**KIRKLEES METROPOLITAN COUNCIL
INVESTMENT & REGENERATION SERVICE**

**DELEGATED DECISION TO DETERMINE APPLICATIONS FOR
CONSENT, AGREEMENT OR APPROVAL REQUIRED BY CONDITION**

Reference No: 2021/44/91537/E

Site Address: Dearne Grange Farm, Park Head Lane, Birds Edge,
Huddersfield, HD8 8YA

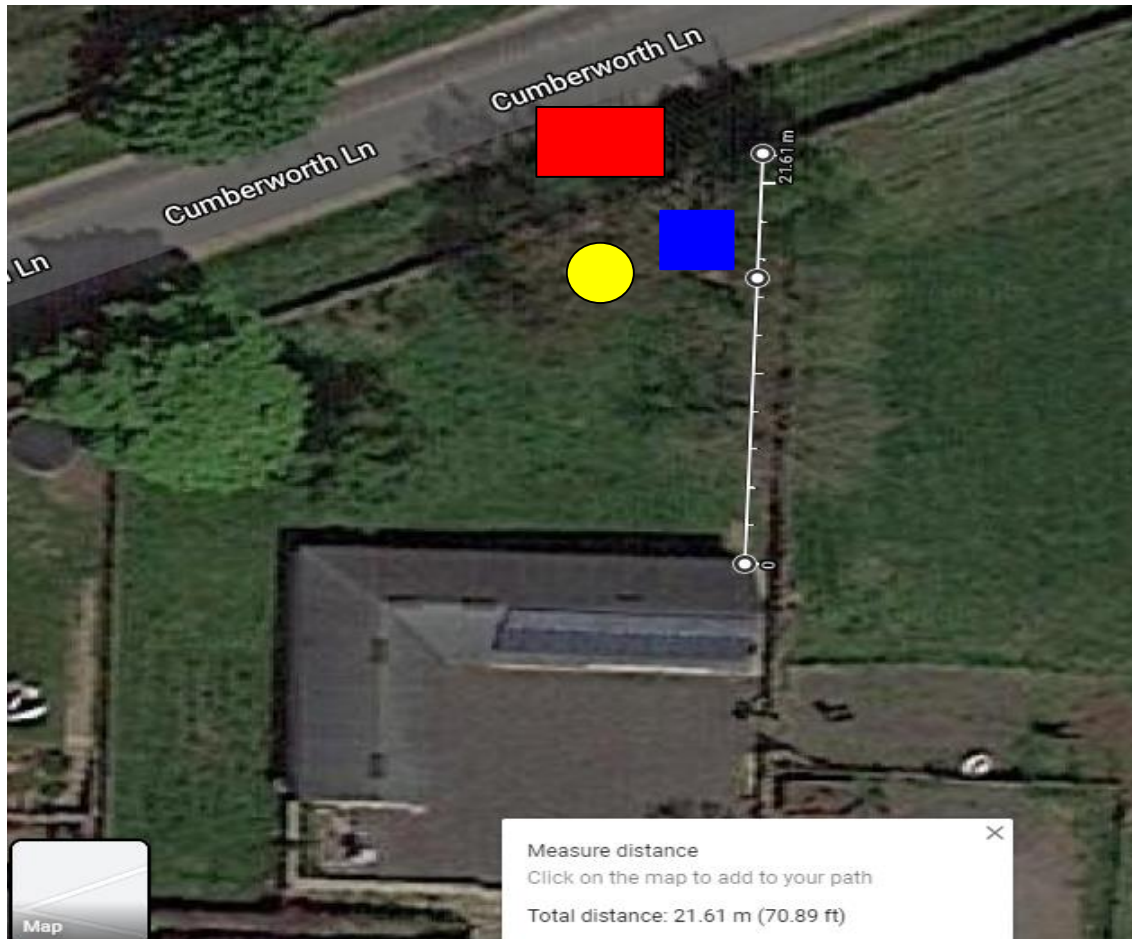
From the provided documents, it is proposed that a Klargester Domestic BioDisc BA domestic package water treatment plant will be sited parallel to Cumberworth Lane within a few meters of the road to allow for vehicle access. The location of the 2m² drainage field is also denoted adjacent to the treatment plant. This is sufficient to allow Condition 14 to be discharged.

BGS map extract:

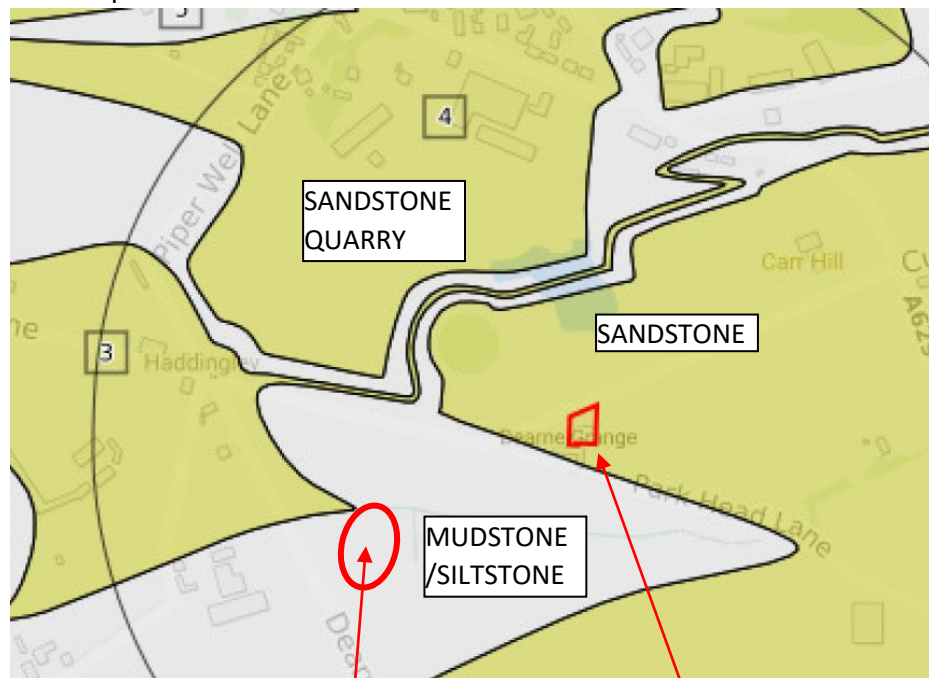
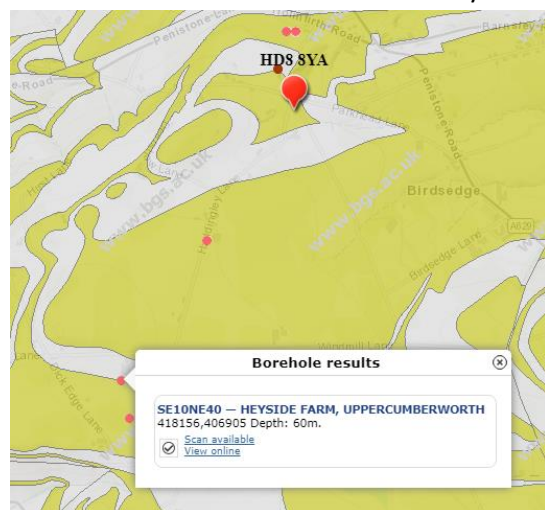
Since then, we identified to the applicant an area of infilled ground (our reference: 71/22) within 250m of the site which had not been considered in the Phase II report. In response, a supporting contaminated land risk assessment dated 18th June 2021 by Geo Investigate has been received. The report includes geo-technical information, which is outside the remit of Environmental Health, this consultation response therefore only relates to the land contamination aspects of the report.

In the new information, Geoinvestigate first question the reliability of the record provided by this service. Next, the report gives reasons as to why the infilling in this area would not pose a risk to the development in relation to topography and geology. Briefly, the author states that due to the contour of the land ground gas migration would be unfeasible. This is supported by a discussion provided about geology.

It is encouraging to see a supporting discussion that justifies the absence of ground gas monitoring at the site. Having read the report provided, we are now satisfied that the ground gas risk has been determined at the site and that Condition 4 should be discharged.
